CITY OF MERCER ISLAND

Pre-Application Meeting (PRE21-052)

Site Location:	7204 78 th Ave SE		
Lot Size:	21,916 sq ft	Zoning:	R-9.6 (Single Family)
Brief Project Description:	Proposal to subdivide existing lot into two lots.	Documents Provided:	<ul style="list-style-type: none">• Project narrative and list of questions• Site plan with tree location information• Topographic survey• Arborist Report
Applicant Information:			
<small>Name:</small>	Peikli Pang	<small>Email:</small>	peikli.pang@5ft2studio.com
		<small>Phone:</small>	425-287-1567
Second Pre-application Meeting Required:	Not Applicable	Click for explanation if necessary

# PRELIMINARY SITE PLAN

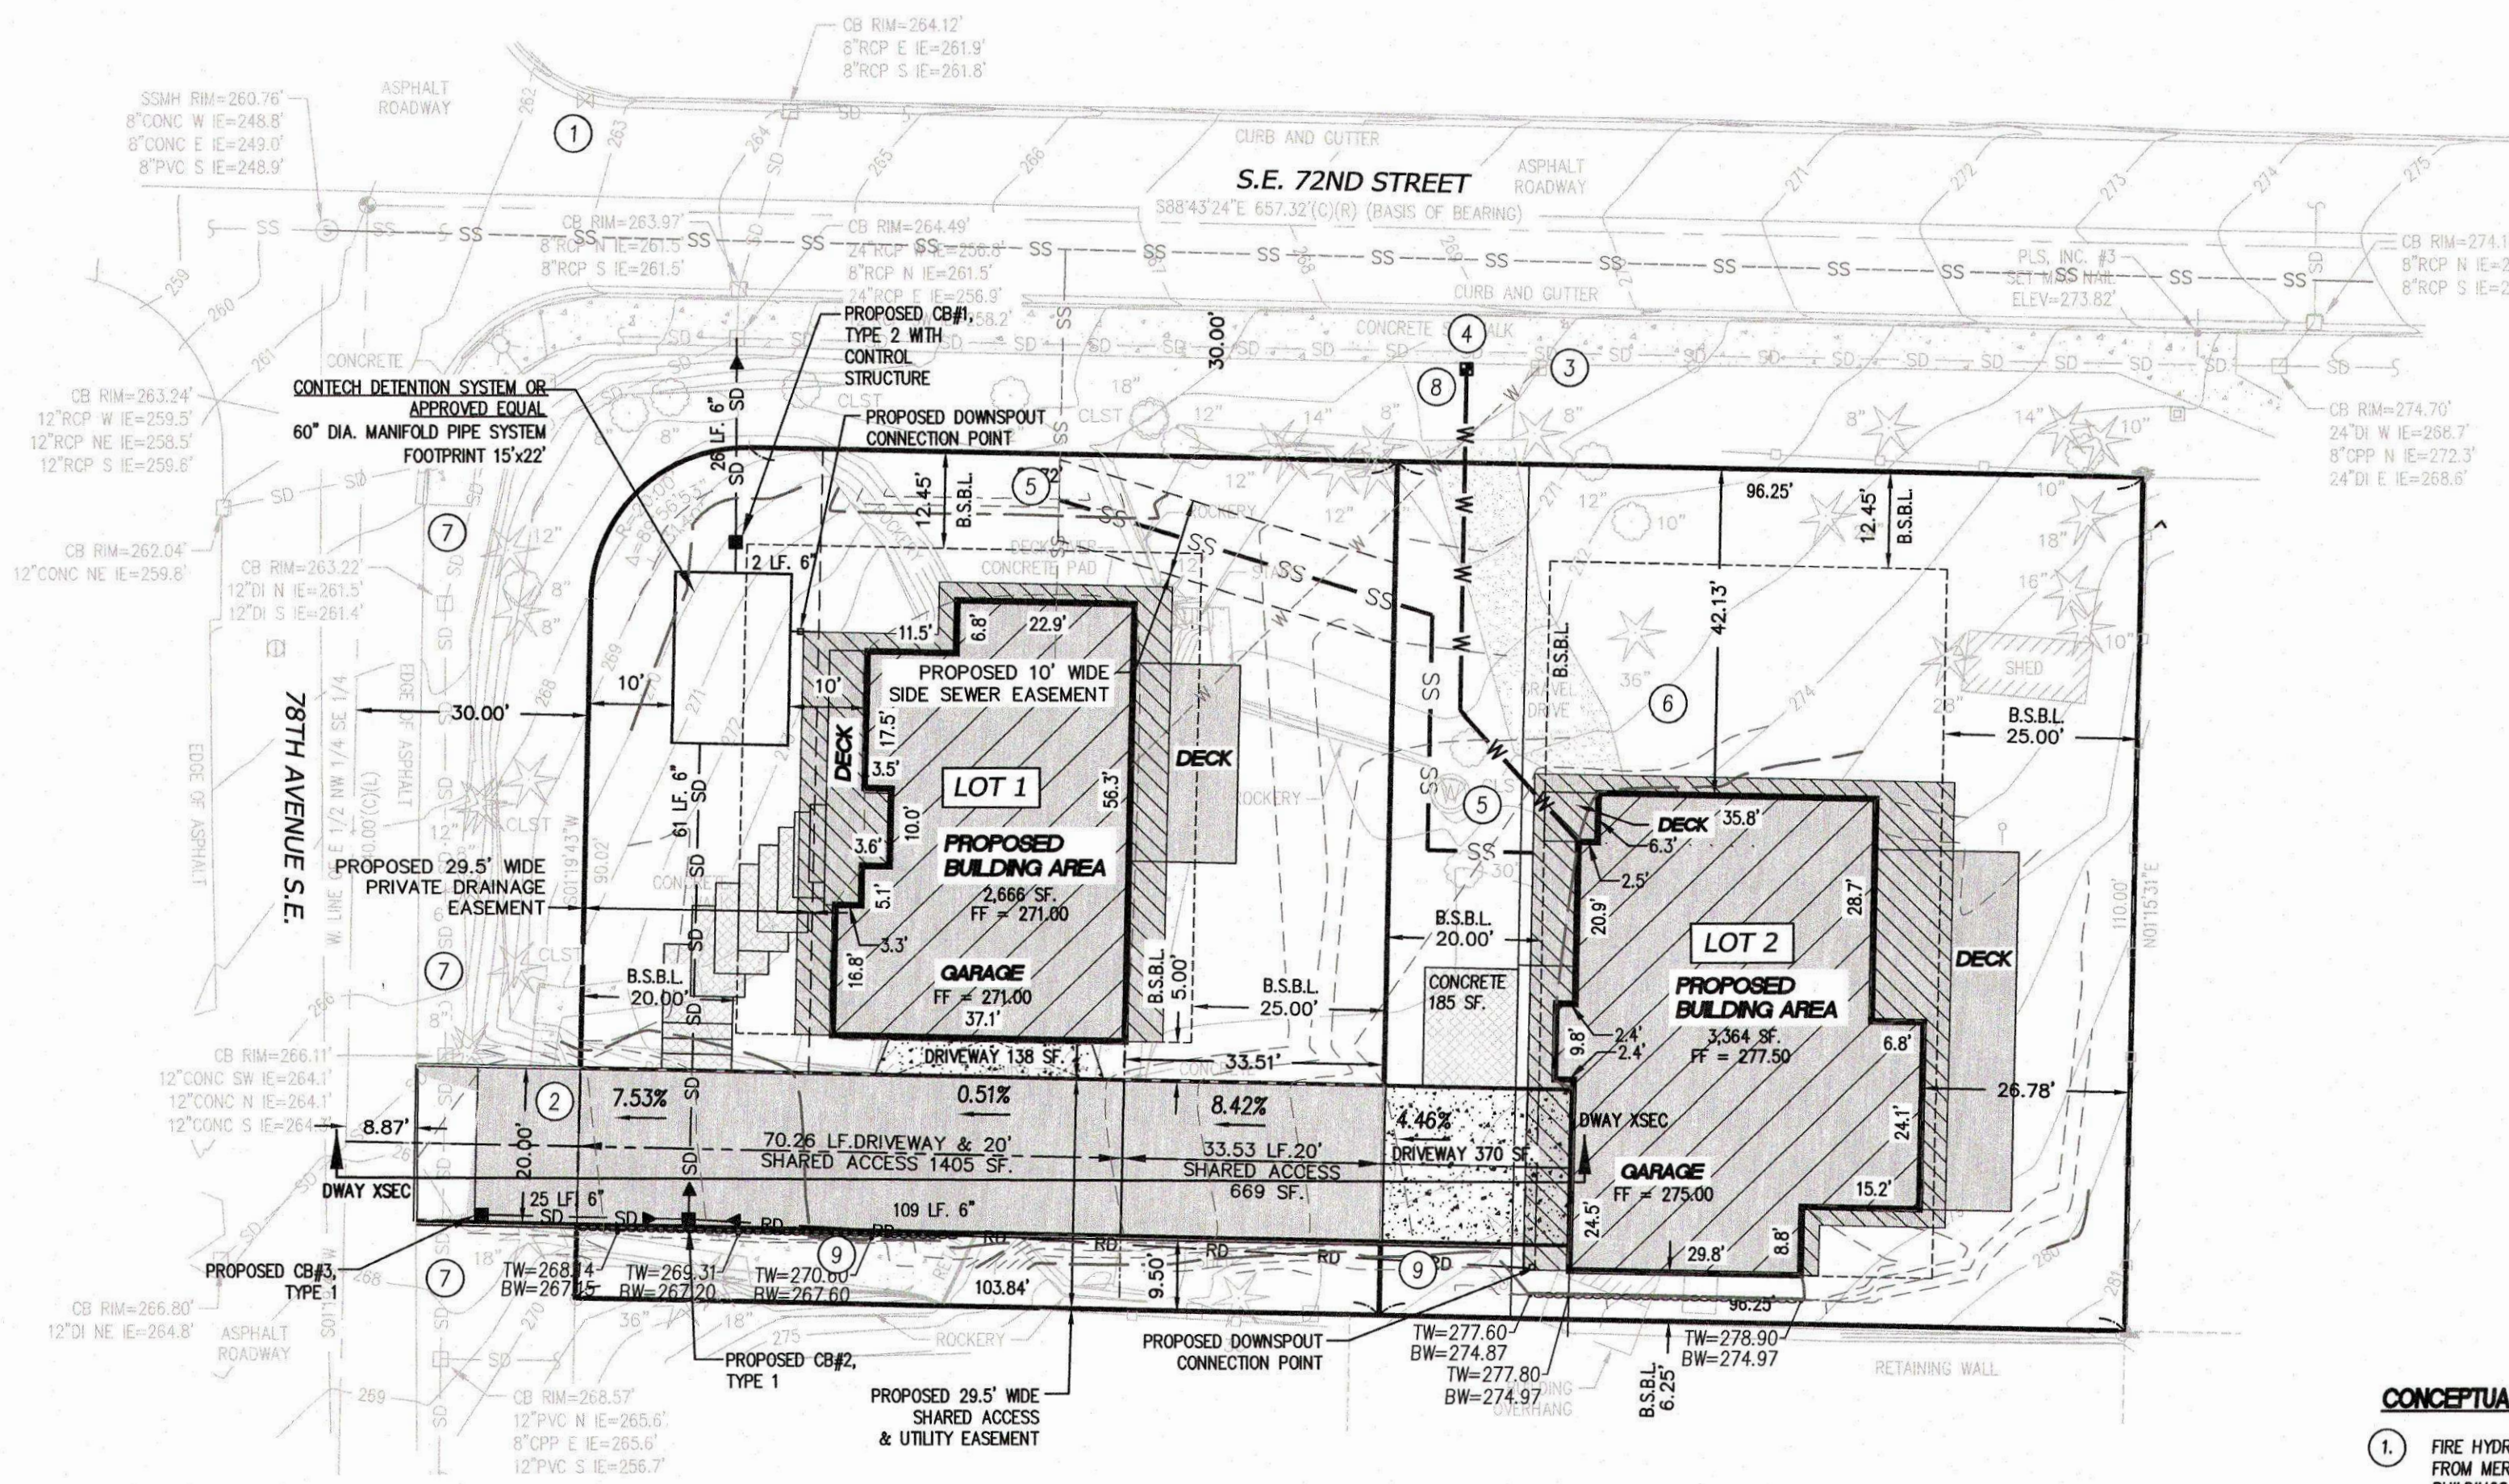
1. A 25 foot rear yard is required for Lot B. The Site Plan shows a rear yard of 24 feet 5.5 inches. Please increase the rear yard to the required 25 feet.
2. The total side yard depth for Lots A and B are 18.7 feet based on the lot widths of 110 feet (i.e. 17% of the lot width). The minimum individual side yard is 6.2 feet (i.e. 33% of the total side yard depth). Note that variable side yard setback requirements may increase the minimum individual side yard requirements based on building height adjacent to the side yards. The greater of the side yard setbacks applies. See MICC 19.02.020.C.1.c.
